29 January 2025

Jessica Watson
Senior Environmental Assessment Officer
Department of Planning, Housing and Infrastructure

State Significant Development - Pottinger Wind Farm - Major Project reference: SSD-59235464

Amber S09E-1

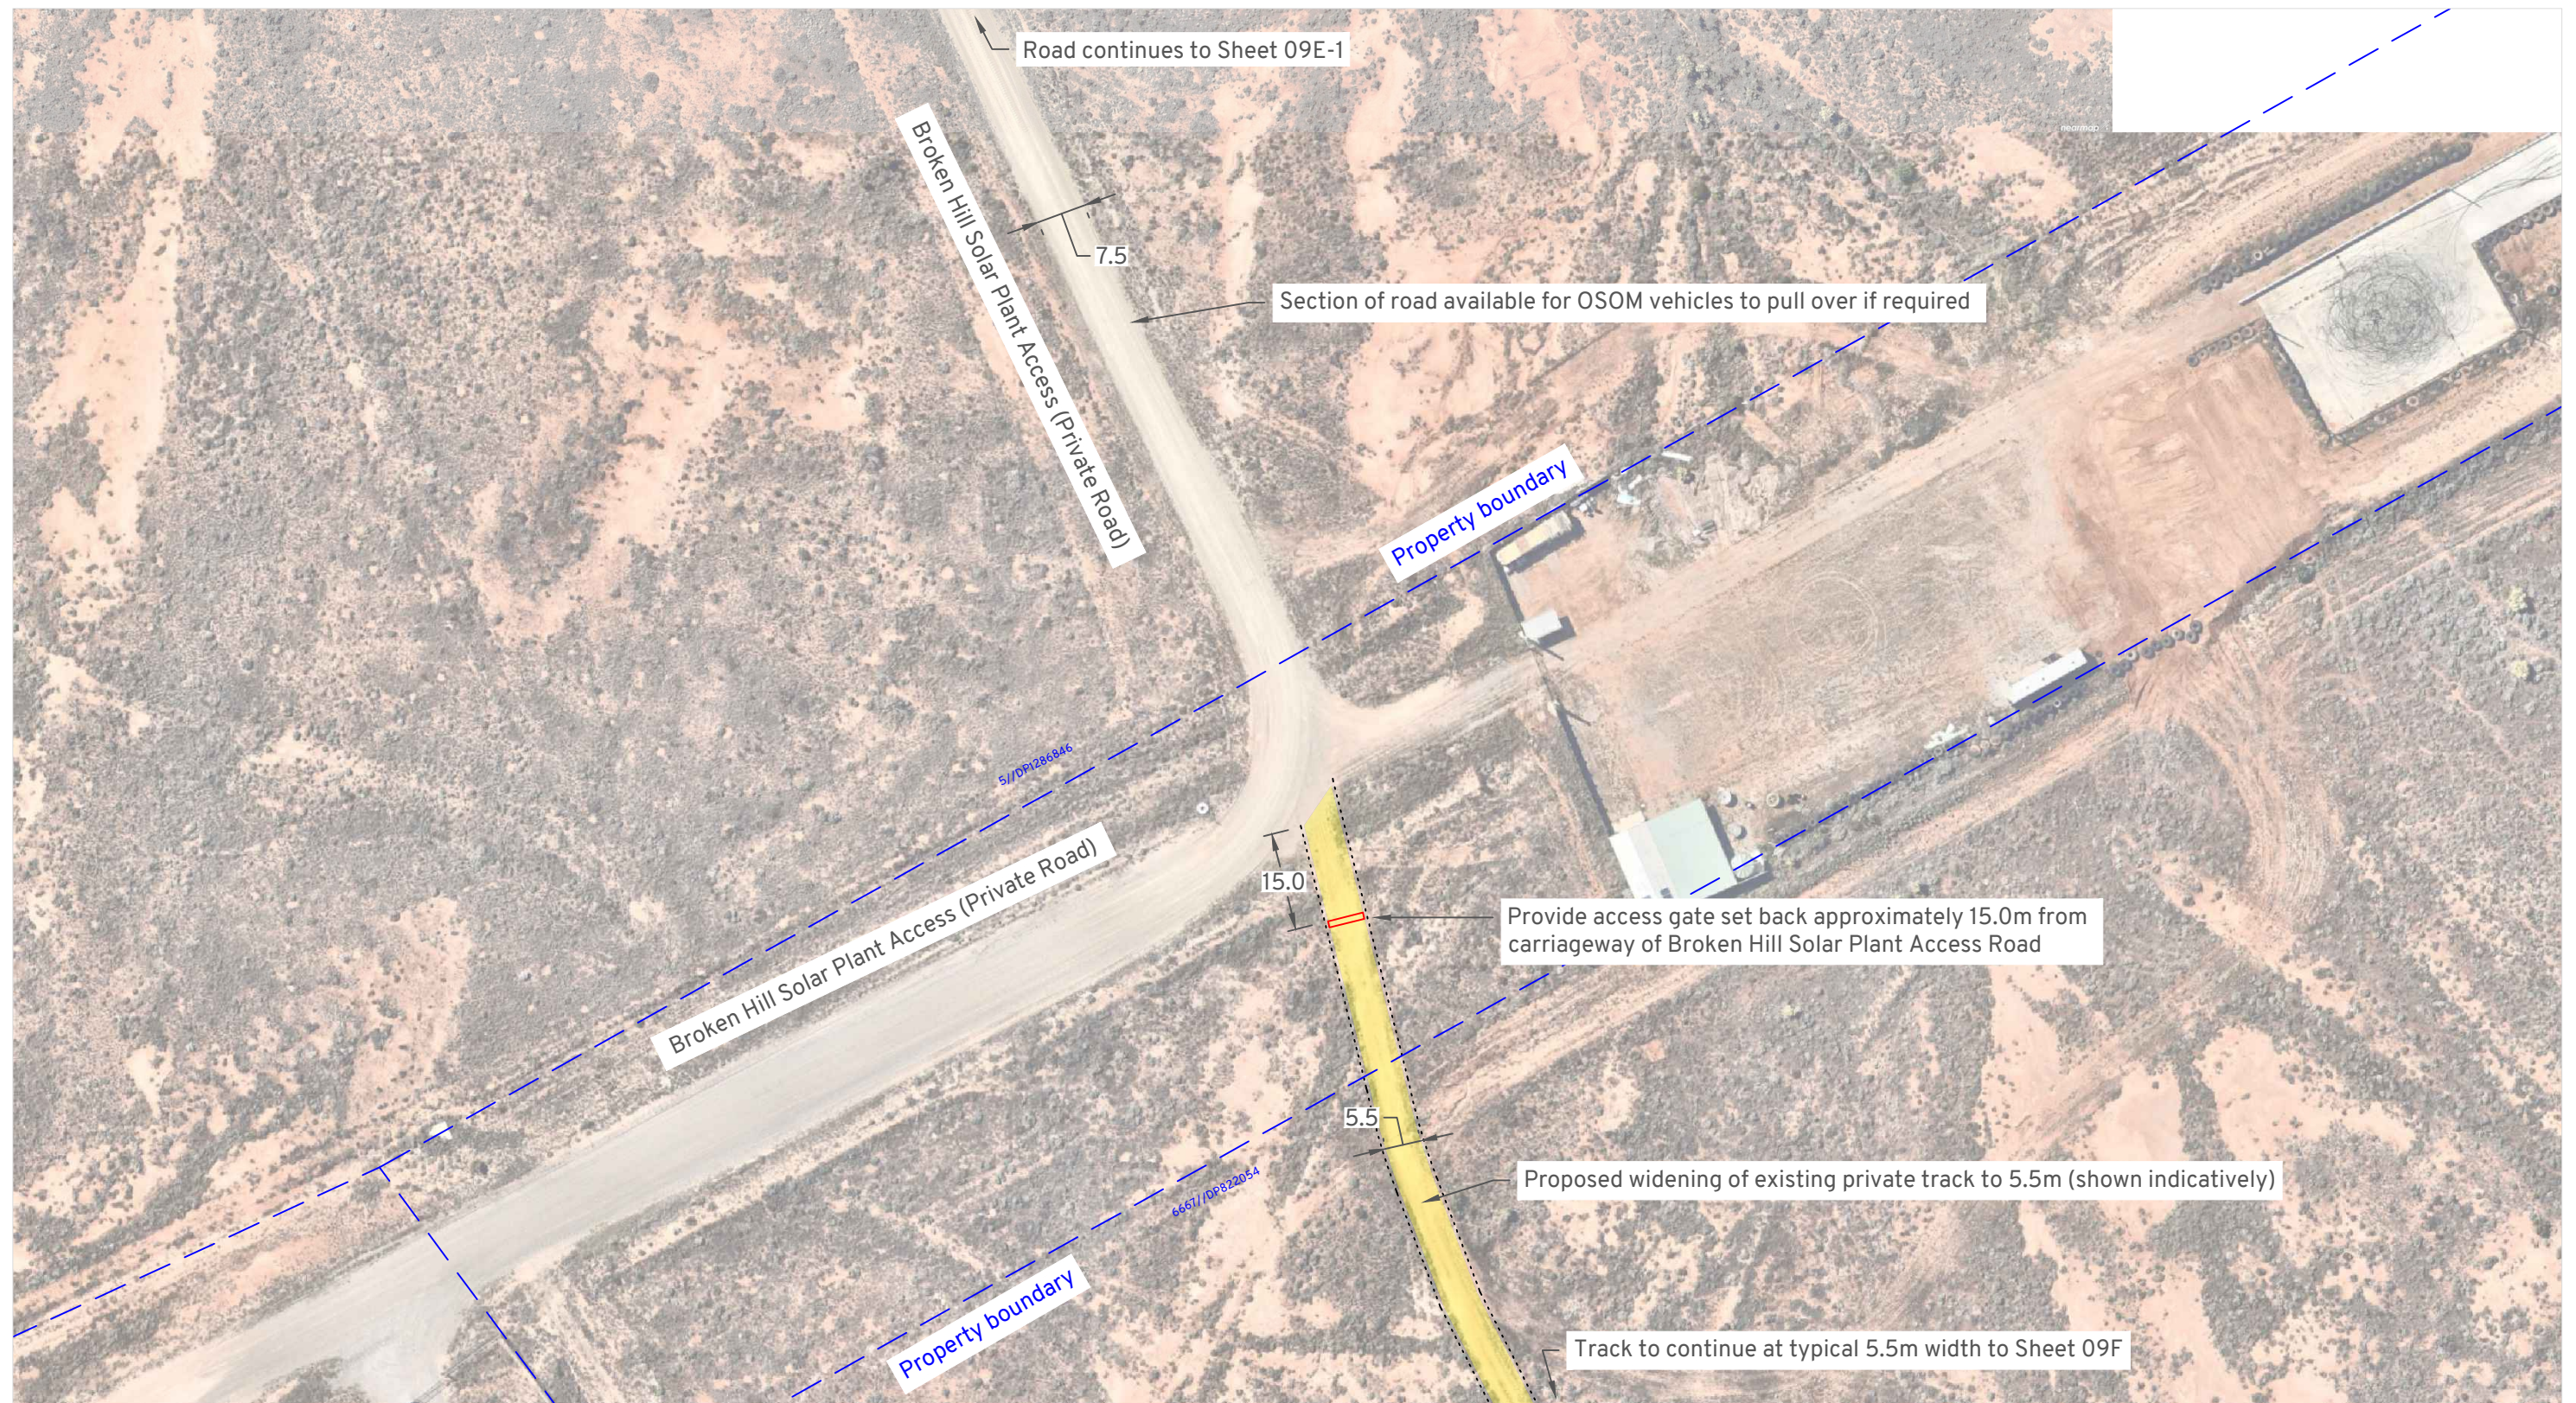
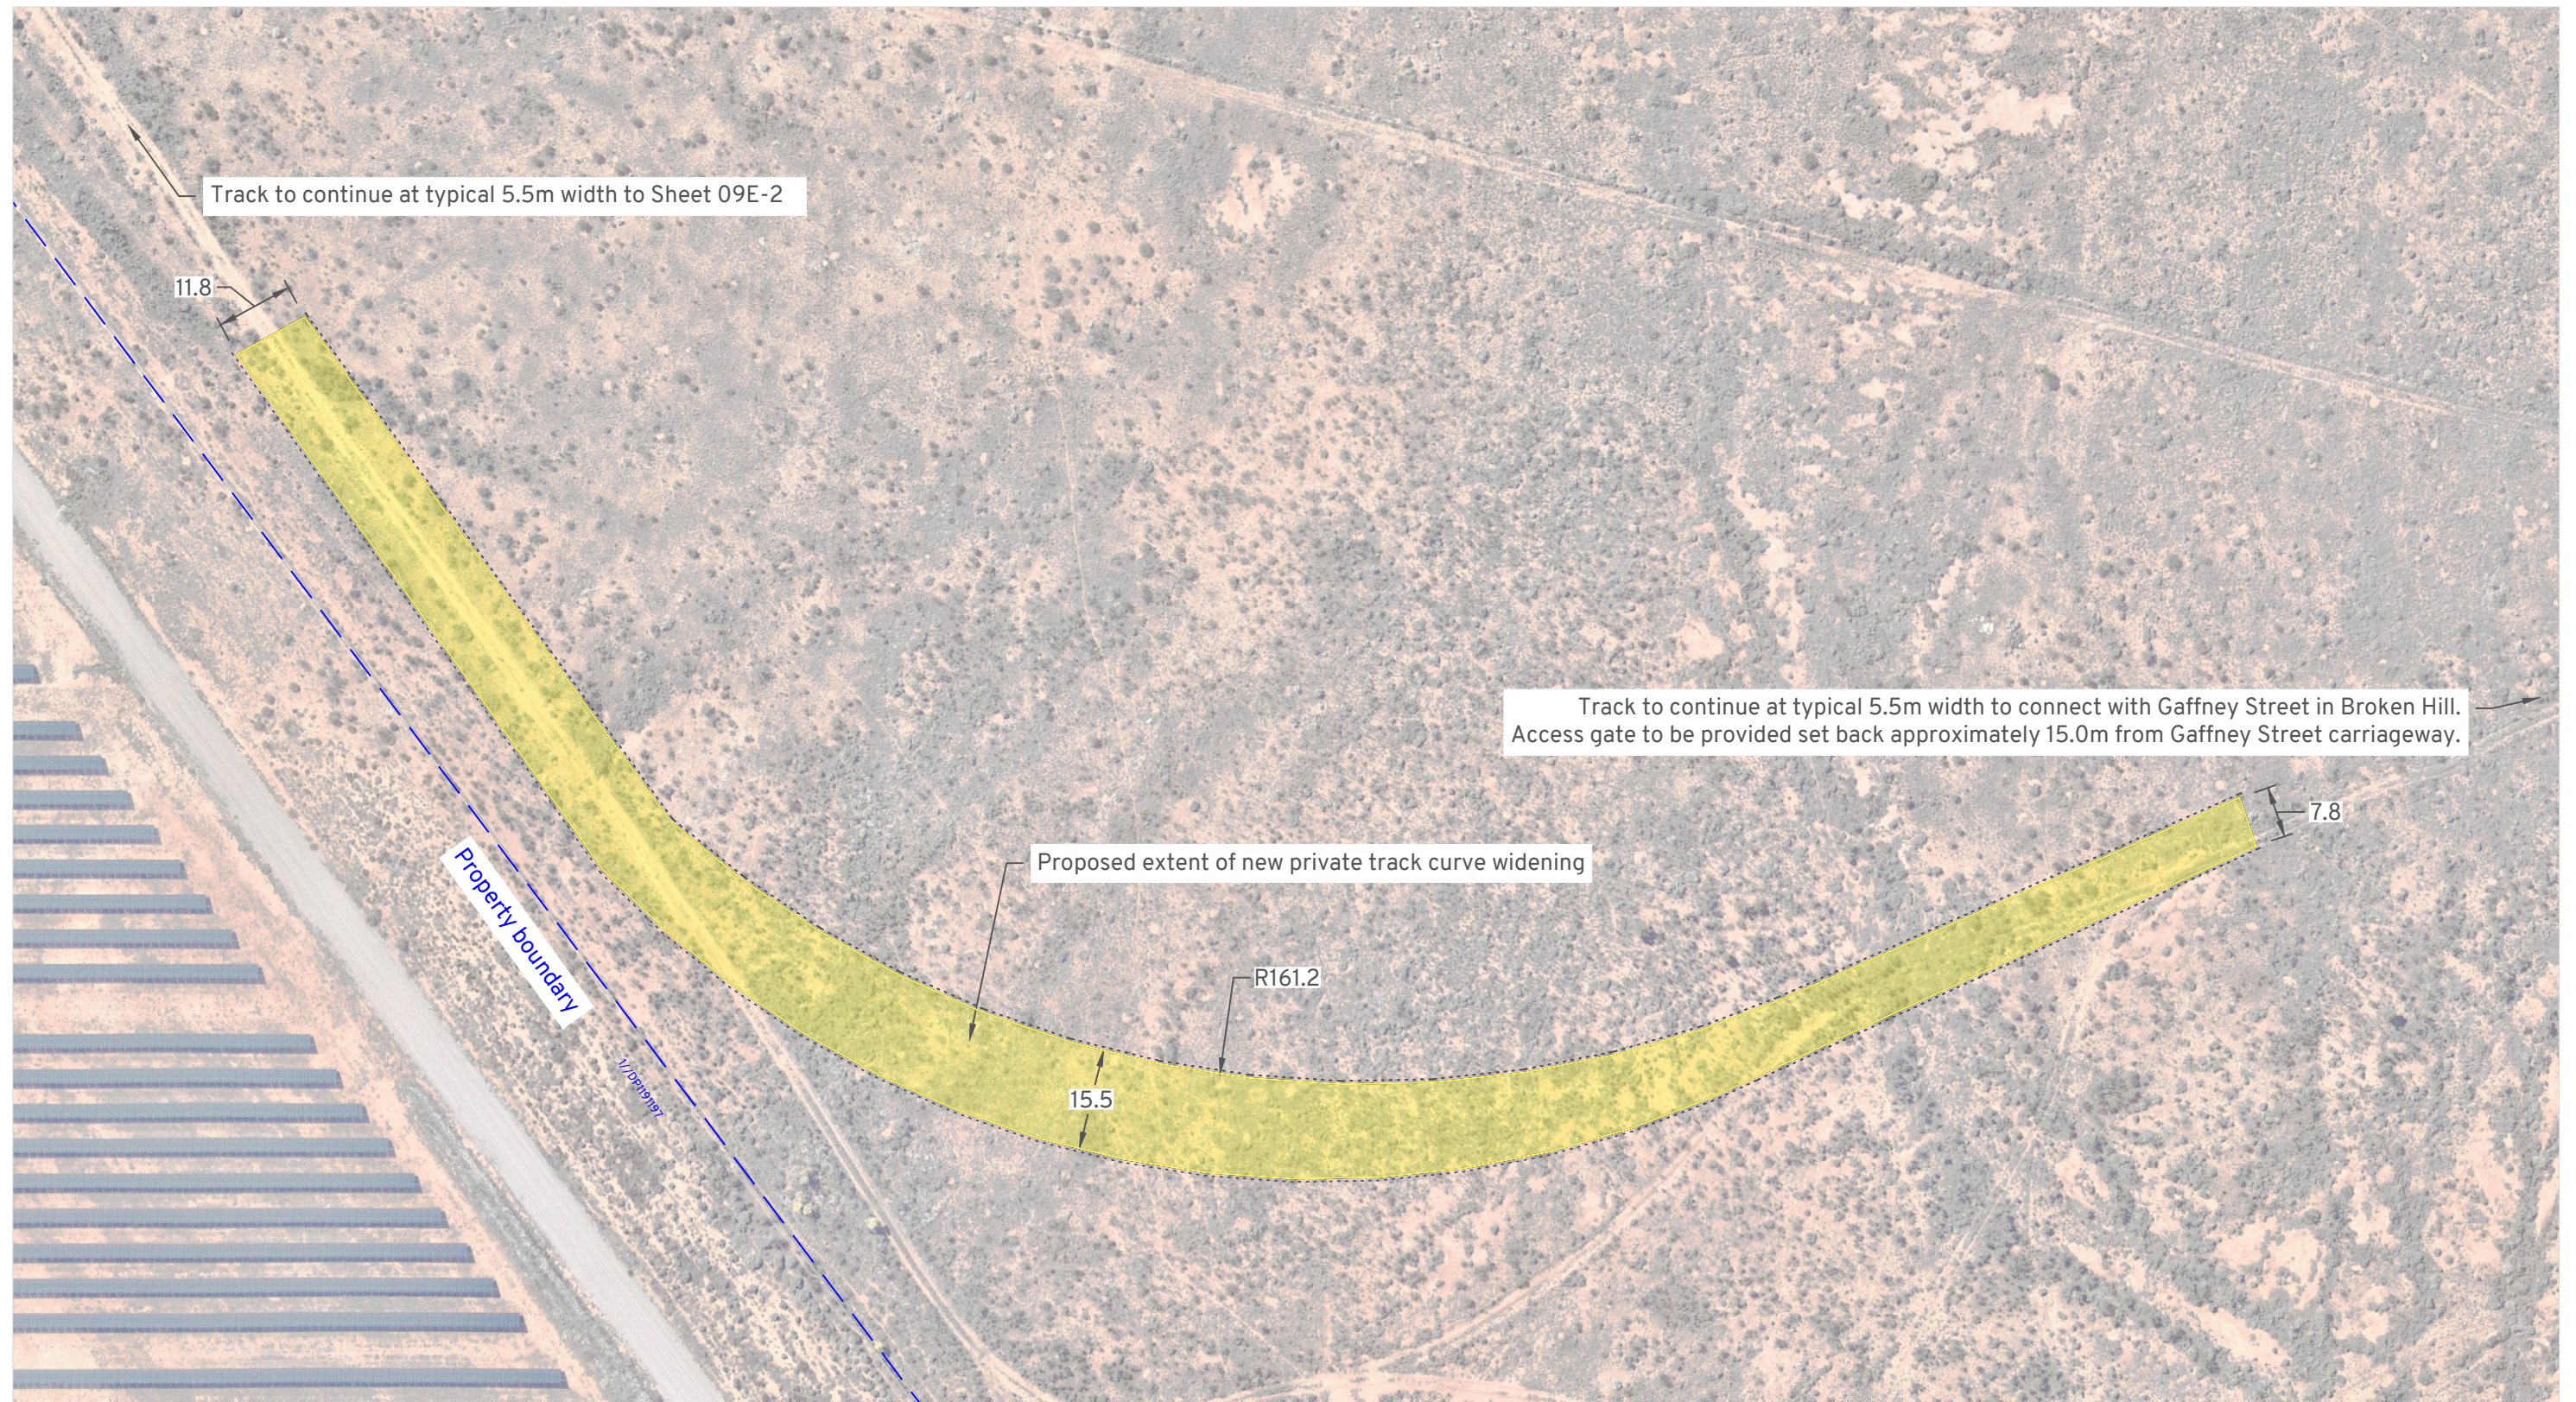
- Council requests clarification be provided by the proponent as to whether the temporary bypass from the Barrier Highway in the Broken Hill LGA, is to be removed.
